Subject: RE: Planning Consultation on: AB/149/17/L

**Listed Building Consent for Alterations, Extension or Demolition of a Listed Building
APPLICATION AB/149/17/L**

Site Address: 44 Tarrant Street Arundel BN18 9DN

Description of Works: Listed building consent for internal alterations & renovations

Job Title	44 Tarrant Street, Arundel		
Client	Mr & Mrs N Field		
Drawing Name	Plans, Lower and Ground Floors		
Drawing Status	Planning & Building Regulations		
Drawn by	AF	Date	11/17
Checked by		Date	
Drawing Scale	1:50 at A1 1:100 at A3		
Drawing No	Status	Revision	
171164/ 103		B

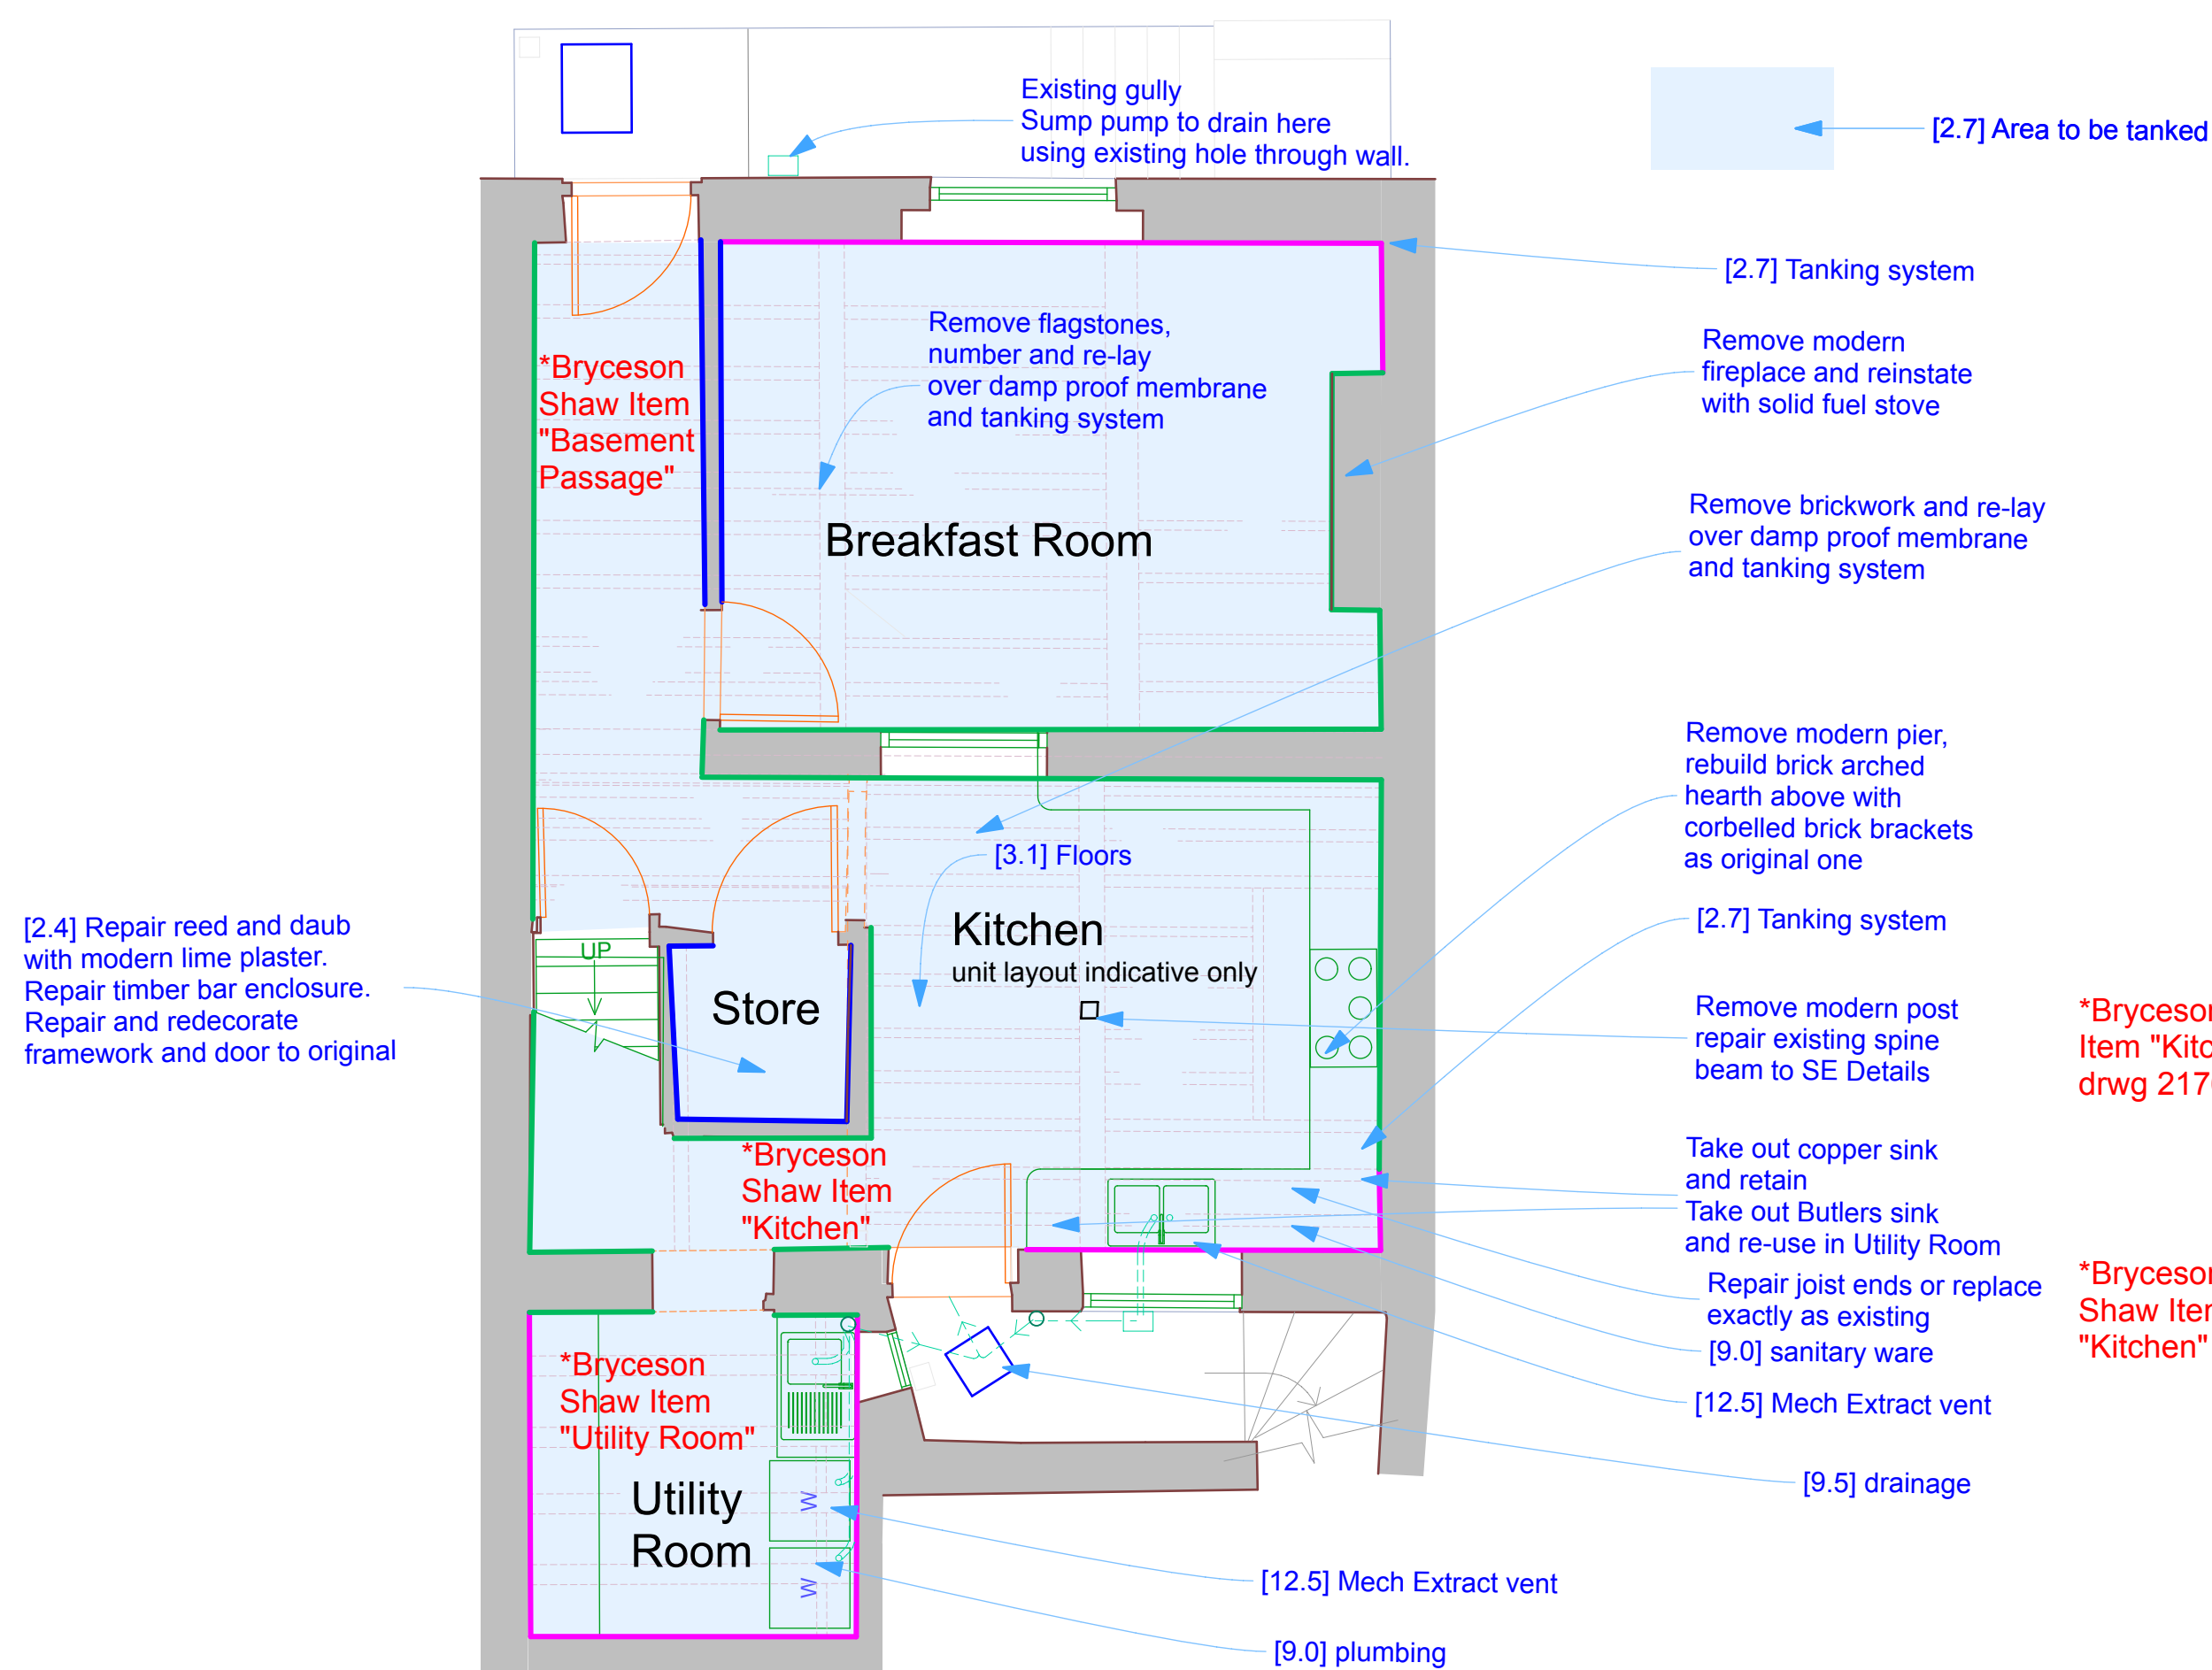
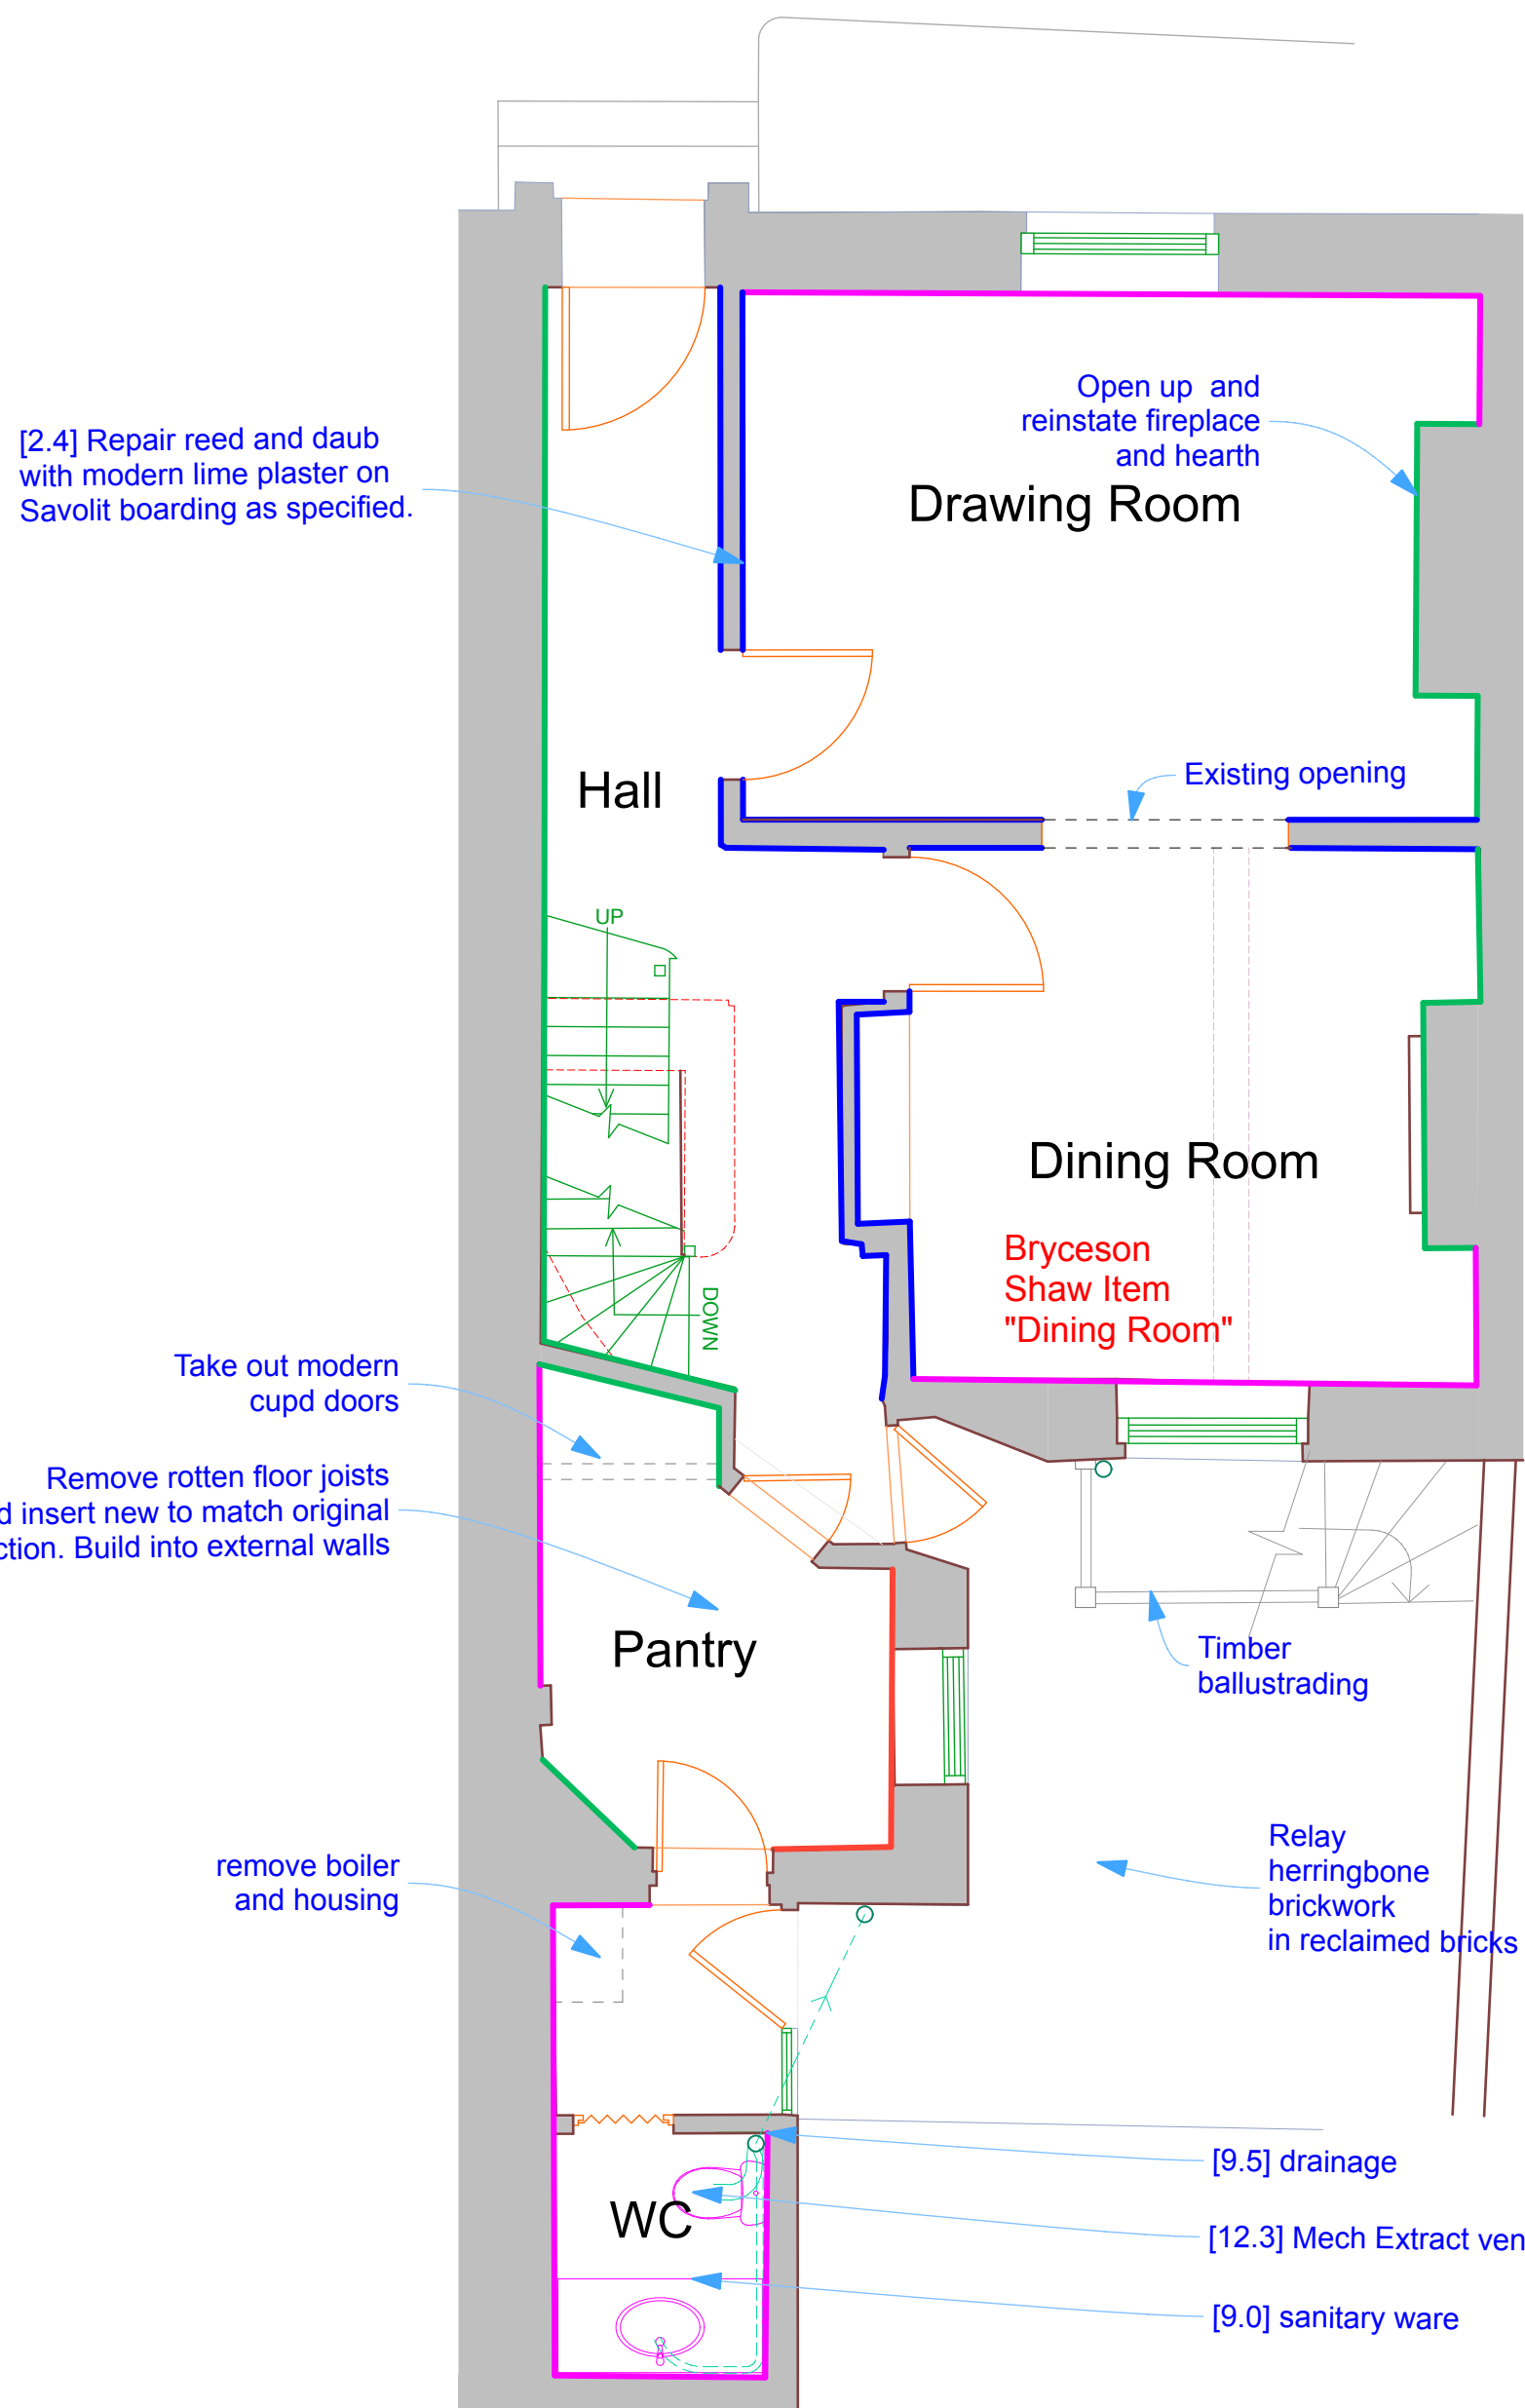
- Existing floor plan. The submitted plans marked 'Planning & Building Regulations', show some dotted lines which I presume to be walls which have been removed. For clarity, a set of plans which show the building before any works had been carried out should be submitted. Such should include features that would appear on plan.

- Submitted Drawings: Works refer to internal works only, while external works appear to have been carried out. It is noted that some reference to 'relay herringbone paving and timber balustrading' is noted on Dwg 17/164/103 Works would appear to exceed this description. Description supplied in 'Description of Works' is incomplete.

- It is unclear as to proposed location of structural drawing 'Proposed Repair' Bryceson Shaw Associates. This detail is not marked on any plans.
- Unclear 'SE Drawing & Report' referred to under 'Kitchen Proposed' – (This is apparently spine beam repair)
